A/110/21/PL

BMW House Chandlers Garage Ltd Water Lane Angmering BN16 4EH

Erection of retirement apartment with 20 No. 1 Bed flats & 13 No.2 Bed flats with communal facilities & car parking, erection of a retail store with car parking & associated highway works. This

East Elevation

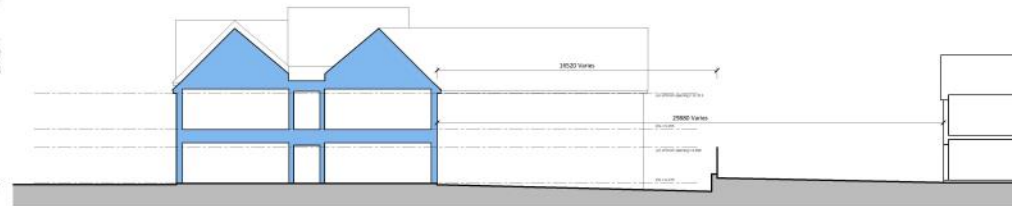
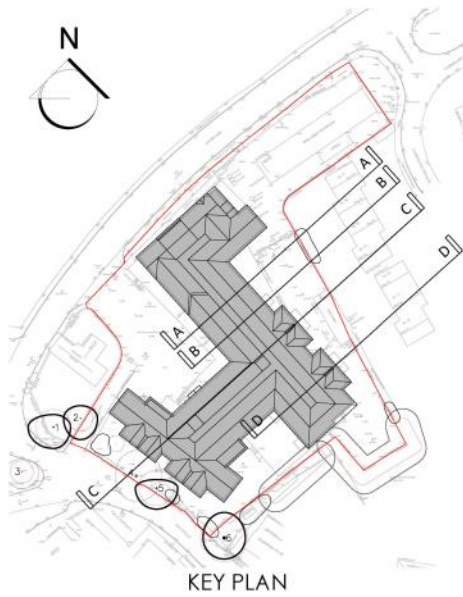
The proposed building covers a large area and would appear to be the largest single building in the local area. The proposed High Street block would sit forward of Eachways, with a higher ridge height. Such a large building would be visible on approaching the conservation area, in the settings on the listed buildings (as indicated in the building massing studies provided as part of the Design and Access Statement). It also appears that the retail element of the building (the northern elevation) would be taller than Eachways and could potentially appear in its setting when viewed from the square/Water Lane – this is in contrast with the existing single storey development. This is out of character and will adversely affect the setting of Eachways.

The High Street is characterised by a variety of building age, style and size. At the western end of the road, and close to the site, the scale diminishes, with a tighter knit and more intimate streetscape. The western element of the new building (i.e. the rendered block which forms the west elevation) is too long and covers a large area. It would appear to be at least two times the ground floor area of Eachways.

At present all of the buildings in the square front on to it, including the listed buildings and the modern house to be demolished as part of the proposal. The layout of the proposed scheme indicates that a number of apartments on the western elevation will all back on to the road/square. This would essentially present the rear of the building onto the public domain, which is out of character. The elevation itself is fairly standard and reads as a block of apartments, as opposed to a terrace of individual homes (a feature of the many buildings which are present on the square and high street. This is disappointing and below the quality expected for such a location.
